Report of the meeting of the Development Control Post-Committee Site
Inspection Panel held on 06-APR-2010

REF NO: FG/5/10/

LOCATION: 9 Sark Gardens
Ferring

PROPOSAL: Single storey front & rear extension. Roof alterations to create 1st floor accommodation including new half hips to gable end walls and dormer windows to front and rear elevations.

PROPOSED ELEVATIONS 1:100

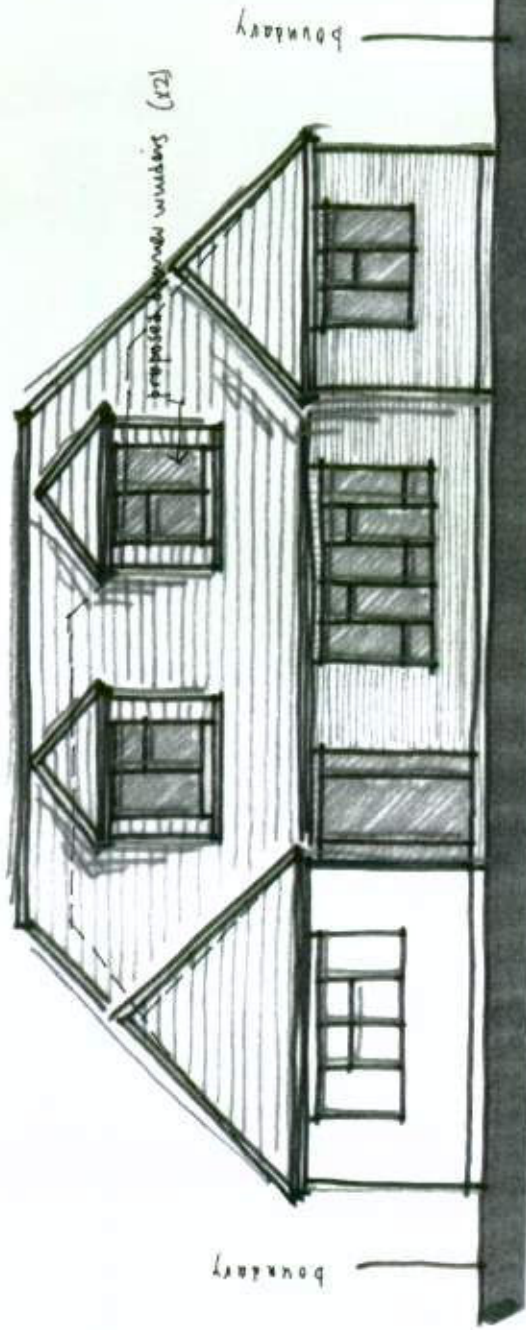
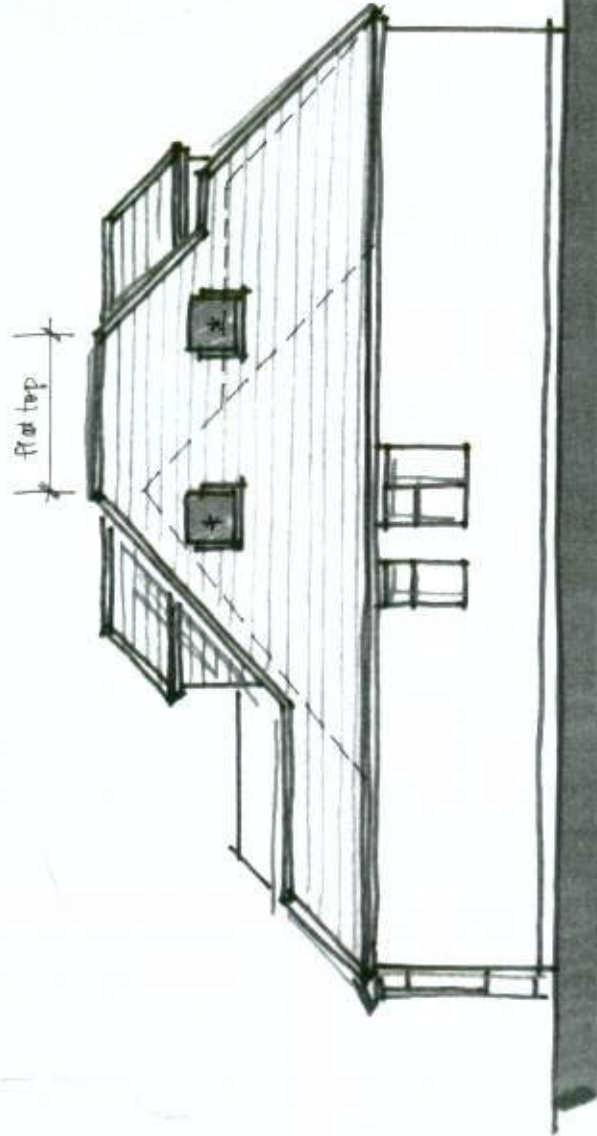
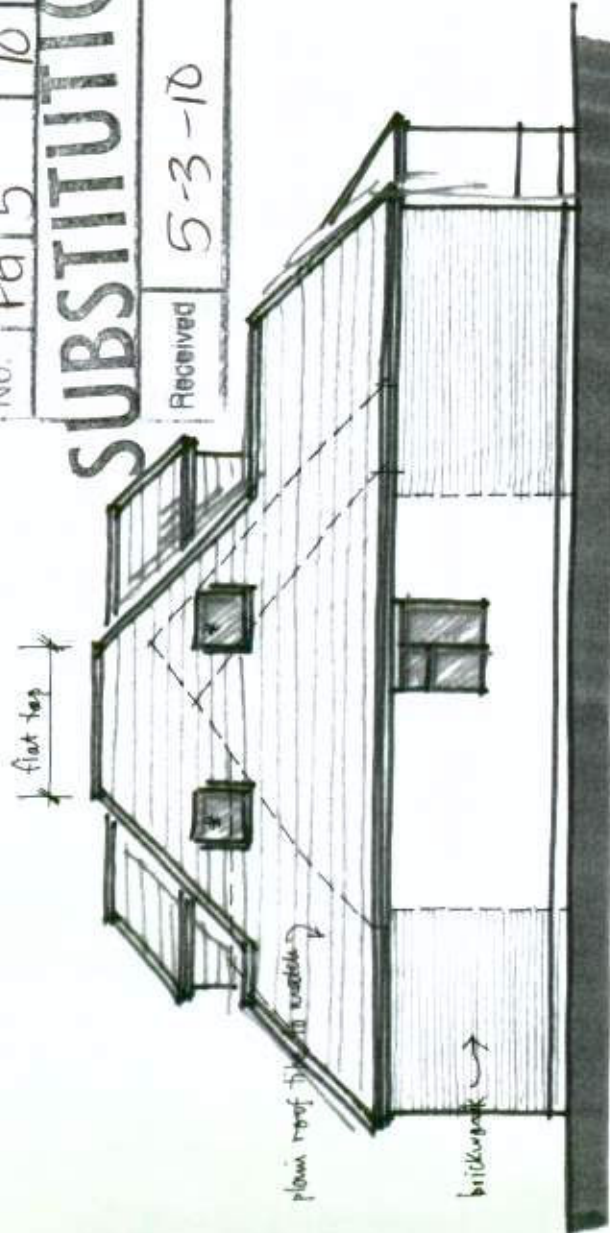
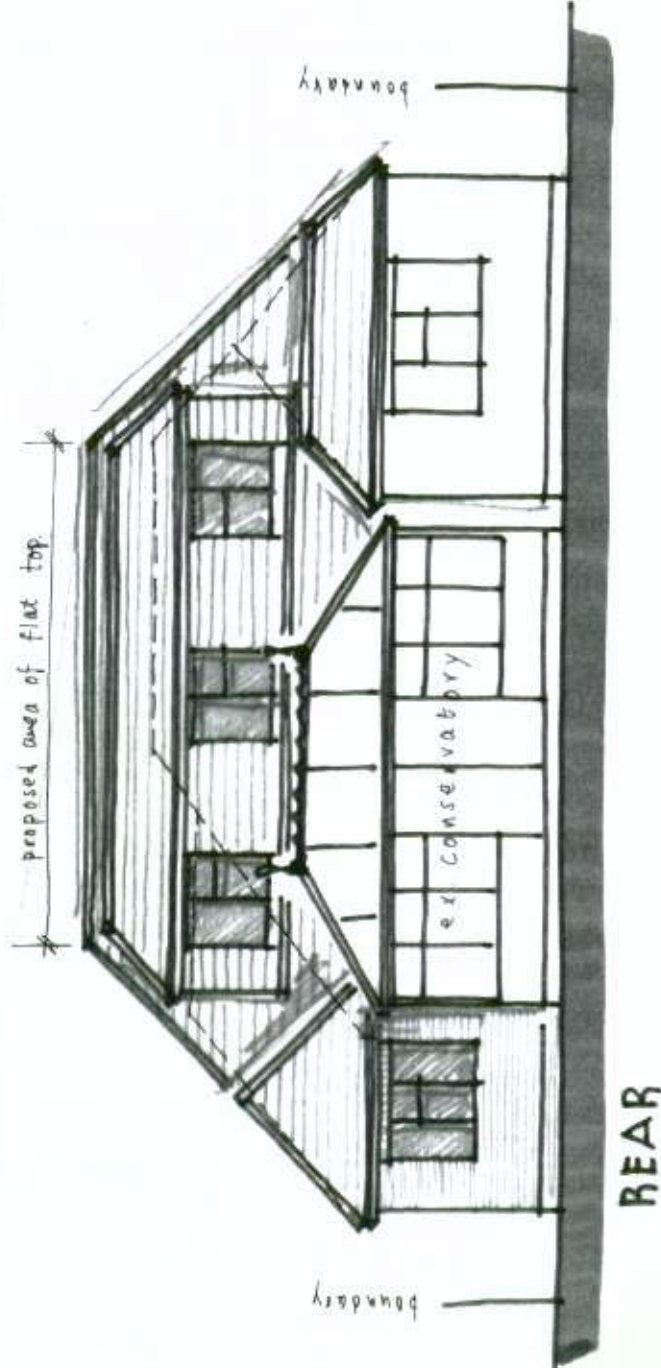
Objection to the amended plans. Do not address the previous reasons for refusal. Extensions not in accordance with the characteristics of the surrounding area. Overbearing in the small close and form an incongruous feature within the street scene. Windows within the roof would overlook neighbouring gardens. Increased roof area would cause further strain on surface water disposal.

Objection: The changes do not materially differ from those previously refused. The proposed extensions would not be in accordance with the characteristics of the surrounding area. Overbearing in the street scene, dormers would overlook neighbouring properties contrary to

GEN7 and DEV19 of the Arun District Local Plan. Would increase strain on surface water disposal contrary to DEV9 of the Arun District Local Plan.

The proposal would reduce the ridge height of the property by approximately 700mm from the previous application and would omit 1 dormer within the front roof elevation reducing the overall scale of the roof extension and would create a hipped roof as opposed to a half hipped roof. To the south of the property is mix of single storey and 1 1/2 storey properties of a similar scale to the proposal, therefore the proposal is not considered to be out of character to the surrounding area. The rear dormer would be some 20m from the property to the east of the site 3 Beehive Close and therefore an adequate distance as to not result in unacceptable overlooking and the front dormers would overlook the open street scene.

The proposed extension would increase the roof pitch of the existing house maintaining a hipped roof with 2No. central pitched roof dormers within front elevation of the dwelling and a flat roof dormer to the rear. The pitched roof dormers by way of their design and scale are considered to sympathetically relate to the existing property and maintain visual subservience. The flat roof dormer will be to the rear elevation of the dwelling and will not impact upon the street scene. Further the hipped roof and the design of the side elevation is considered to maintain the existing characteristics of the bungalow. The proposed roof extensions therefore do not result in demonstrable harm to the character and appearance of the existing dwelling nor the surrounding residential area.

The rear dormer would maintain a distance of some 20m from the property to the east of the site No.3 Beehive Close and some 17m to boundary adjoining the site which is considered to be an adequate distance as to not result in unacceptable overlooking of the property to the rear of the site. The front dormers would overlook the open plan street scene and would not result in overlooking of private amenity areas of neighbouring properties.
